From: Ian Stocks [REDACTED] **On Behalf Of** FRS Water and Access
Sent: 13 May 2021 09:53
To: Planning.Responses <Planning.Responses@arun.gov.uk>
Subject: Hydrant condition - CM/17/21/PL Land at Wren Cottage Horsemere Green Lane Climping BN17 5QZ

HYDRANT CONDITION CONSULTATION WITH PLANNING AUTHORITY

Planning Ref: CM/17/21/PL

Description: Development of 2 No. 2-bed & 2 No. 3-bed detached dwellings & associated works (resubmission following CM/53/20/PL). This site is in CIL Zone 3 & is CIL Liable as new dwellings.

SITE PLAN
SCALE 1:500 @ a3

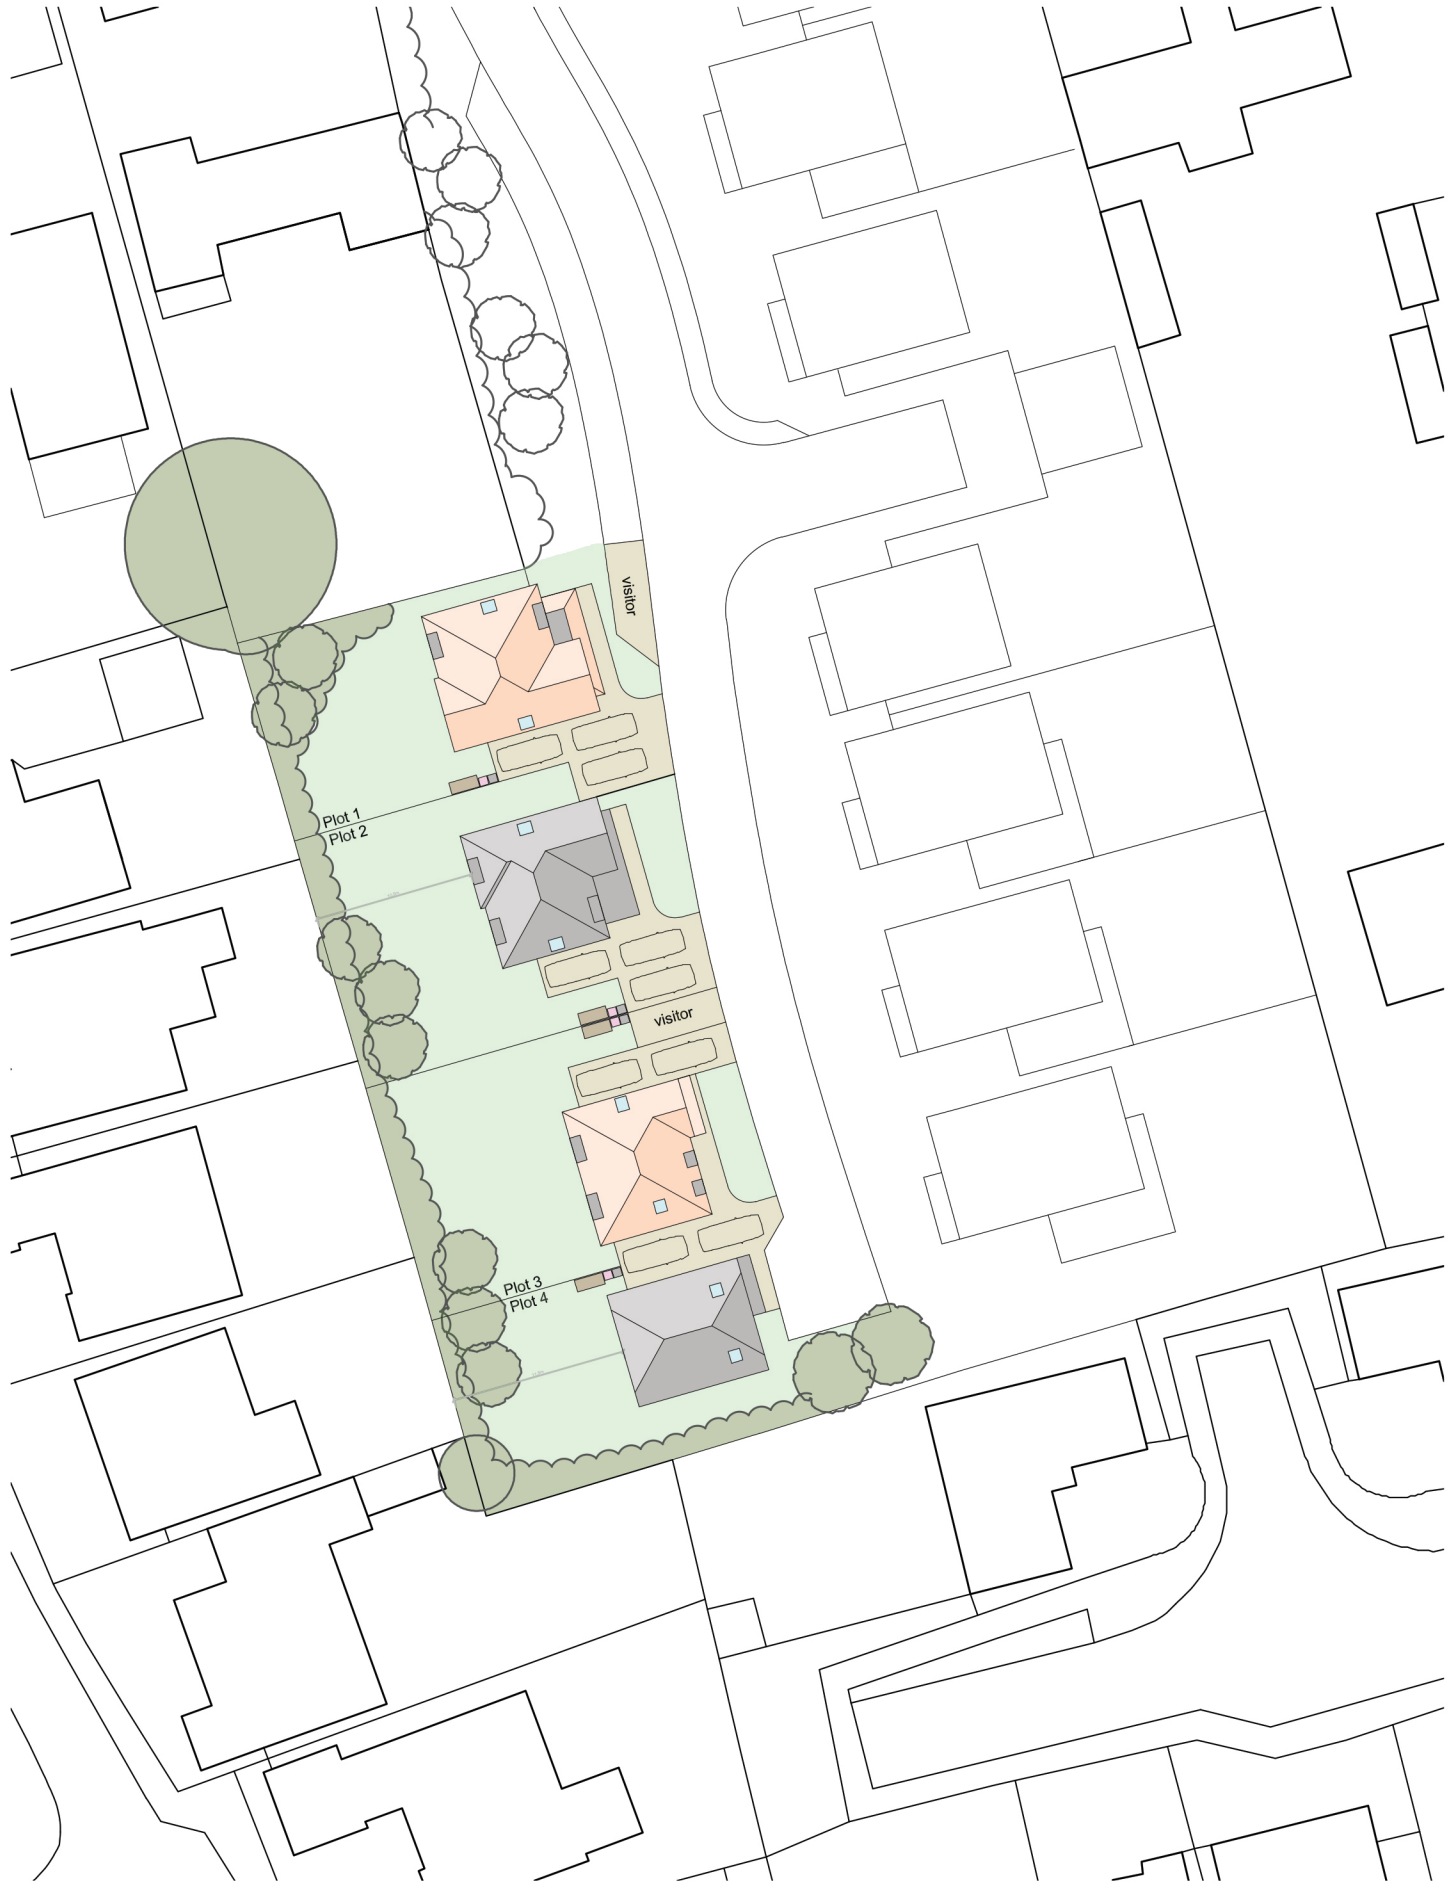
Please find attached a planning condition for application no. CM/17/21/PL for the requirement of an additional fire hydrant. Currently the nearest Hydrant to these proposed properties is 260 metres away. The supply of water for firefighting for a domestic premises should be within 175 metres.

Evidence will also be required that Fire Service vehicle access meets with the requirements identified in Approved Document B Volume 1 2019 Edition: B5 Section 13, including Table 13.1 and diagram 13.1.

- 1) Prior to the commencement of the development details showing the proposed location of [1] one fire hydrant or stored water supply (in accordance with the West Sussex Fire and Rescue Guidance Notes) shall be submitted to and approved in writing by the Local Planning Authority in consultation with West Sussex County Council's Fire and Rescue Service. These approvals shall not be unreasonably withheld or delayed.
- 2) Prior to the first occupation of any dwelling/unit forming part of the proposed development that they will at their own expense install the fire hydrant (or in a phased programme if a large development) in the approved location to BS 750 standards or stored water supply and arrange for their connection to a water supply which is appropriate in terms of both pressure and volume for the purposes of firefighting.
